WEST SUSSEX COUNTY COUNCIL CONSULTATION

TO:	Arun District Council FAO: Raymond Cole
FROM:	Stephen Gee WSCC - Highways Authority
DATE:	17 April 2020
LOCATION:	Land at Ford Airfield Ford, West Sussex
SUBJECT:	F/4/20/OUT Outline planning application (with all matters reserved except for access) for the development of up to 1,500 dwellings (Use Class C3), 60-bed care home (Use Class C2), up to 9,000 sqm of employment floorspace (Use Classes B1), local centre of up to 2,350 sqm including up to 900 sqm retail / commercial (Use Classes A1-A5) and 1,450 sqm community / leisure floorspace (Use Classes D1-D2), land for a two-form entry primary school (Use Class D1), public open space, allotments, new sports pitches and associated facilities, drainage, parking and associated access, infrastructure, landscape, ancillary and site preparation works, including demolition of existing buildings and part removal of existing runway hardstanding. This application affects a Public Right of Way. This application is the subject of an Environmental Statement. This application falls within CIL Zone 1 - Zero Rated.

T:\Projects\13000 Series\13091\118 Ford Airfield\Tech\Arch\Transport Drawings\Working Drawings\GA\ITB13091-GA-037.dwg

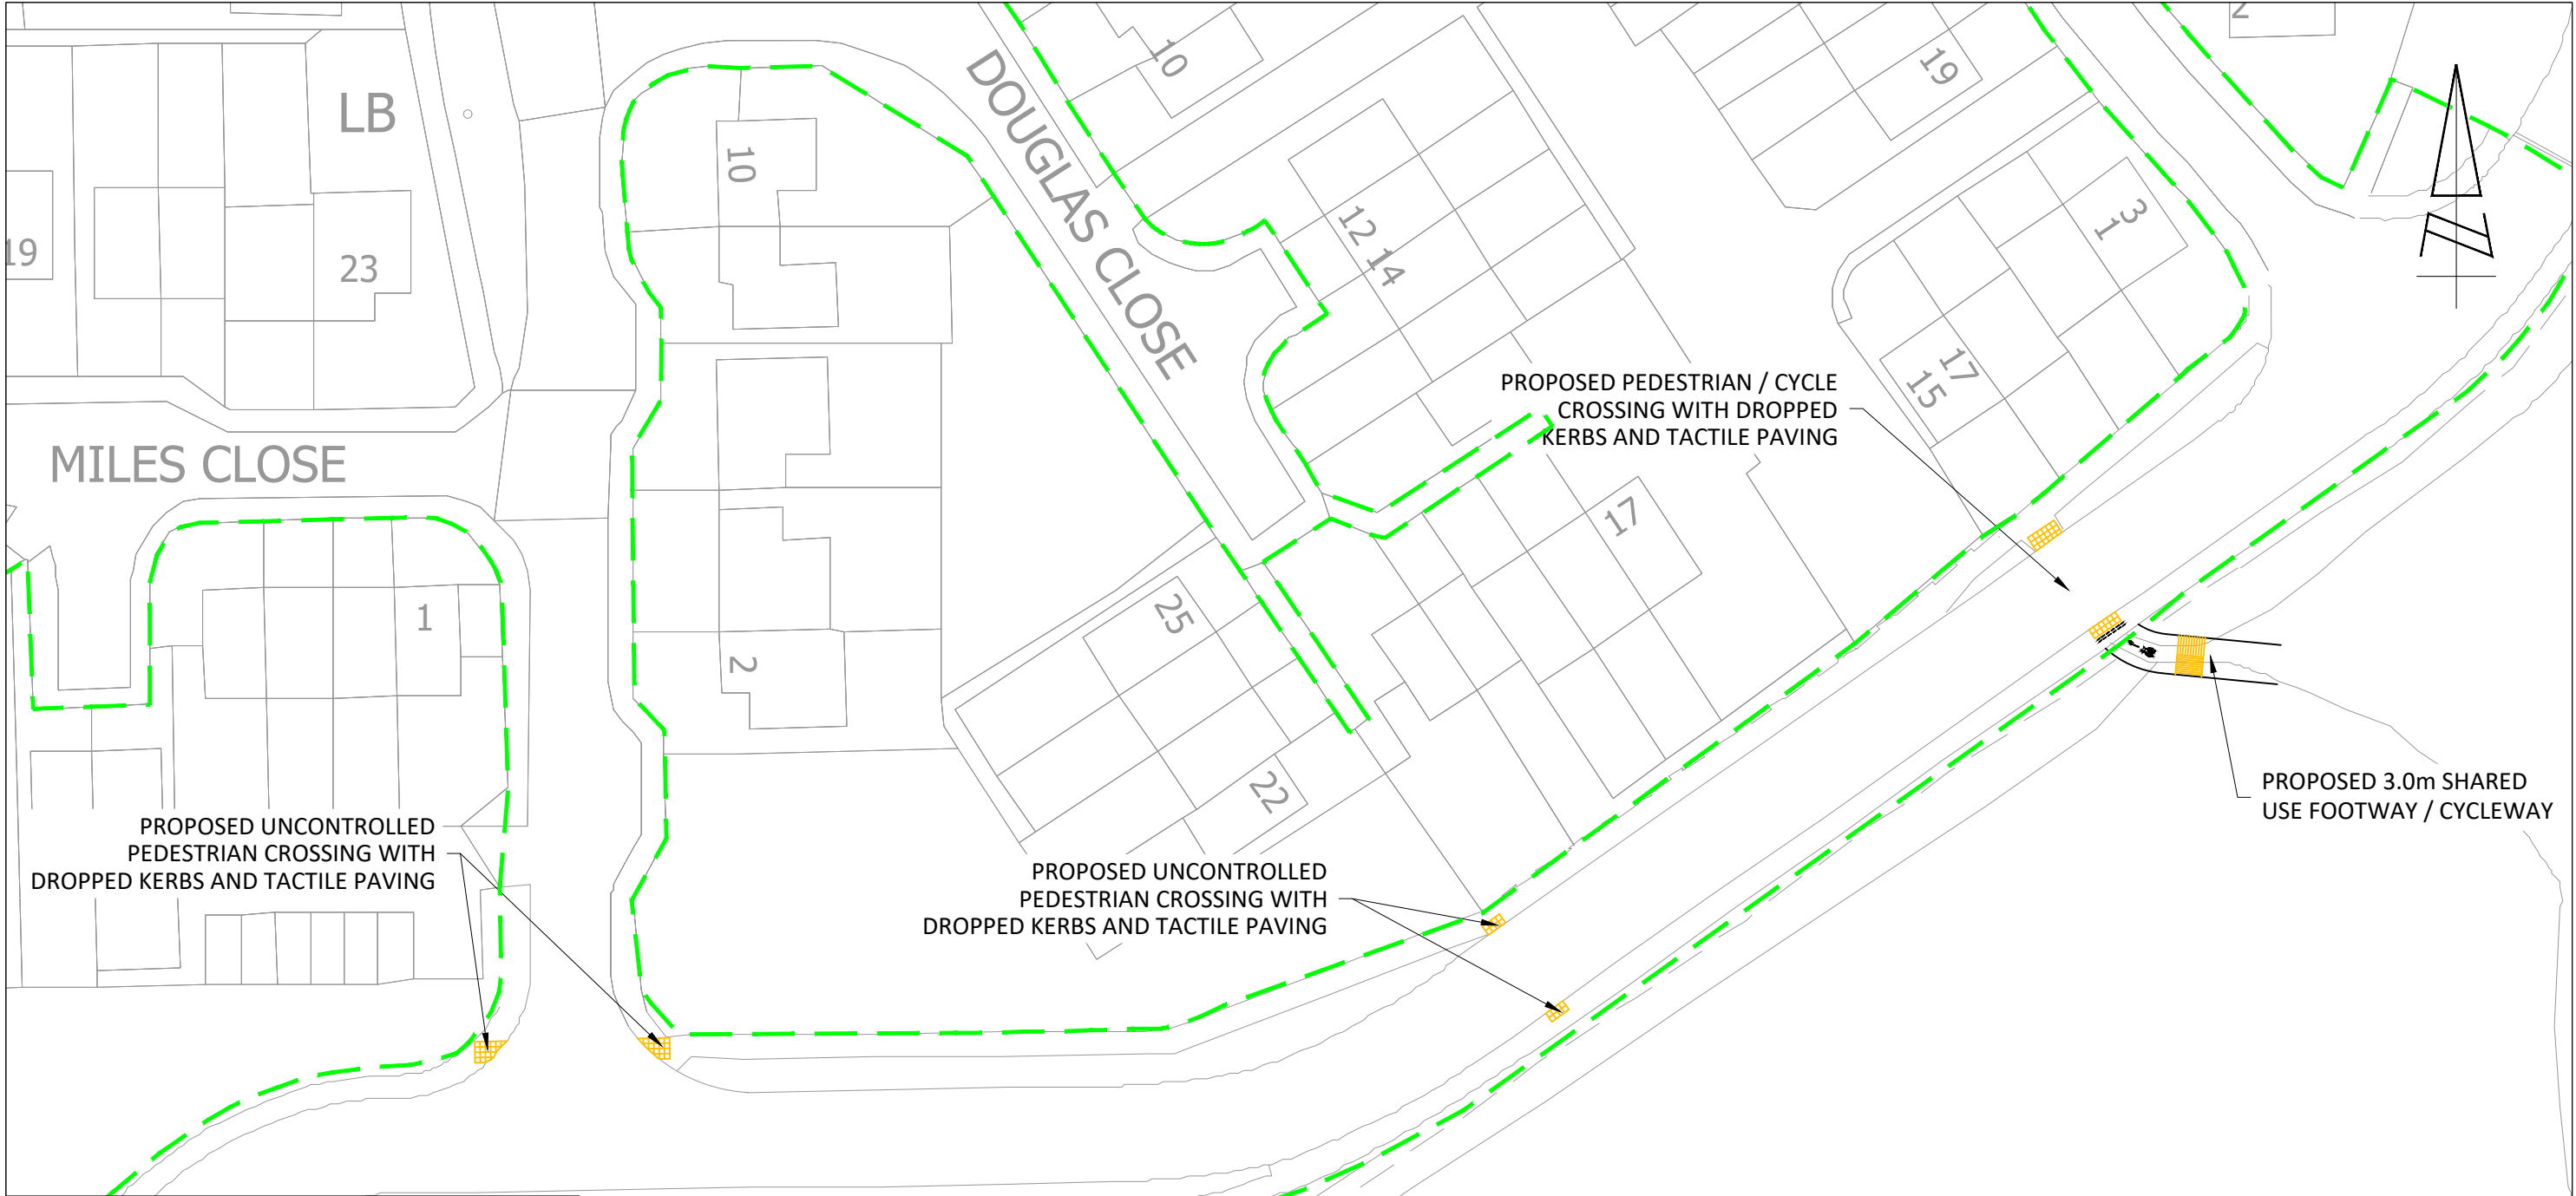
Within the site, the area identified for employment use will be accessed by the extension of the consented Grundon Access Road. The arrangement comprises the extension of the 7.3m carriageway as well as the 2.0m footway located on the western side of the carriageway. The access arrangement is presented in drawing ITB13091-GA-037.

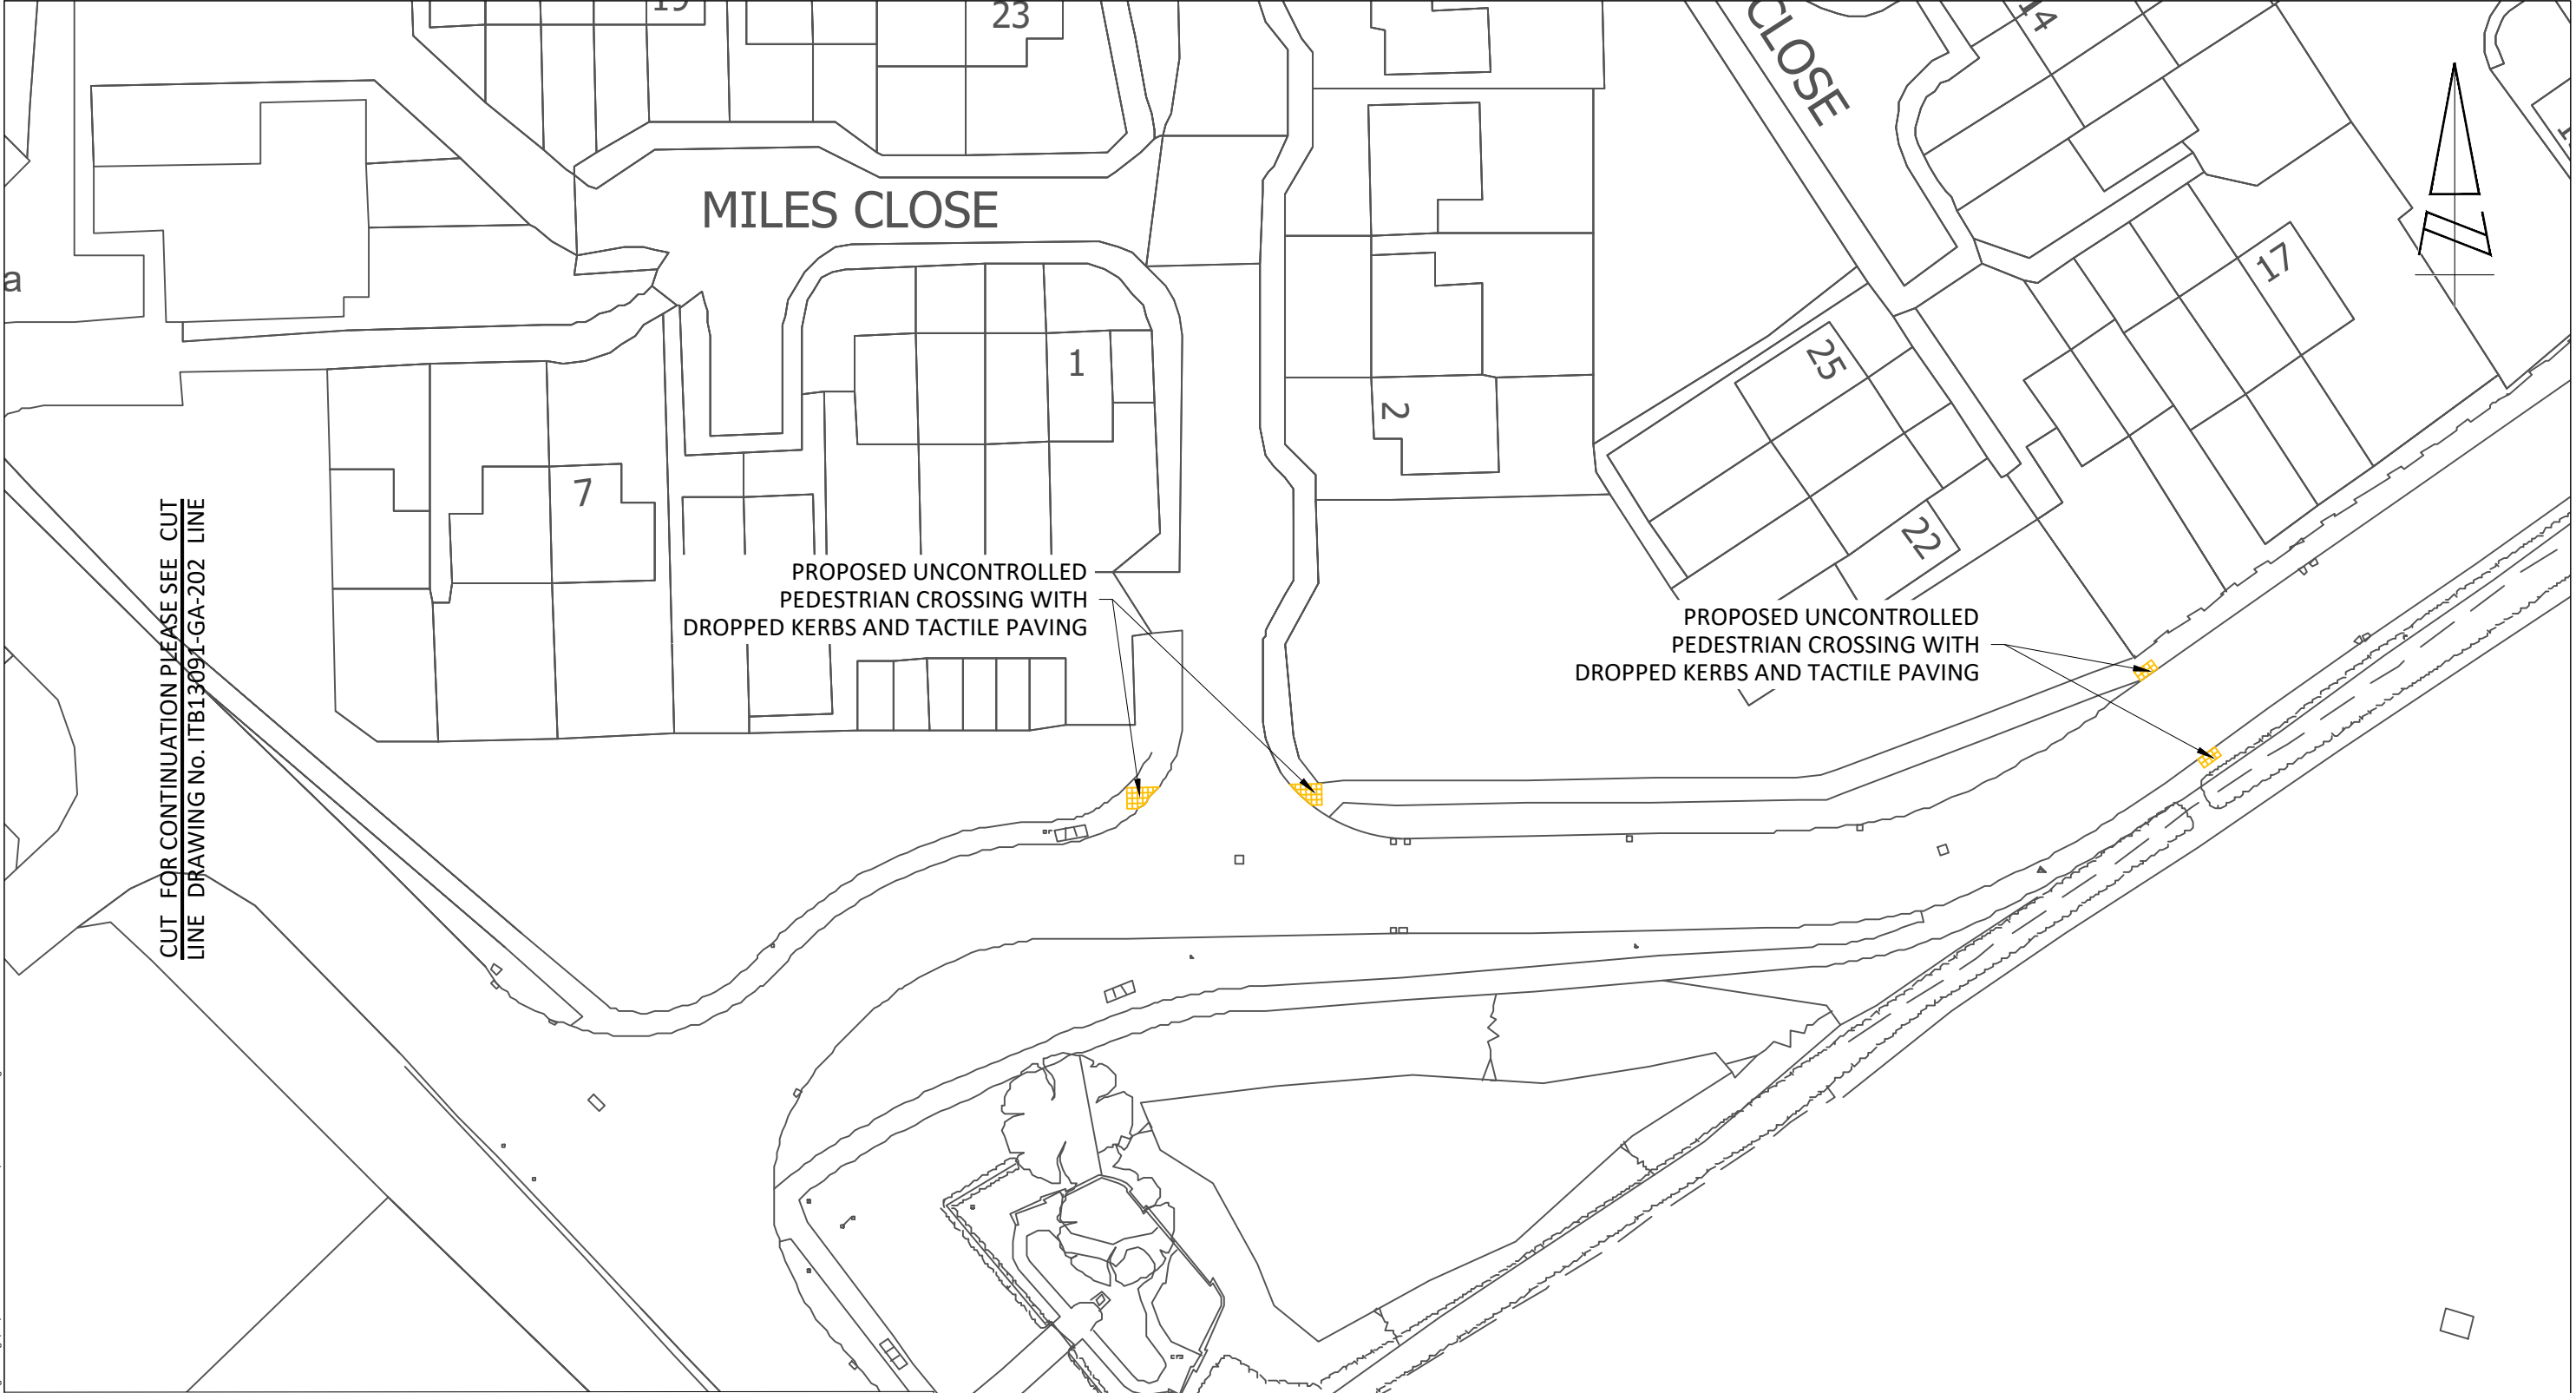
A 2m wide footway is to be provided onto Ford Lane and an adjacent footway provided in front of Wickes Cottages. As shown on ITB13091-GA-054. The full extent of the

provision in both directions along Ford Lane should be identified to determine a safe termination point.
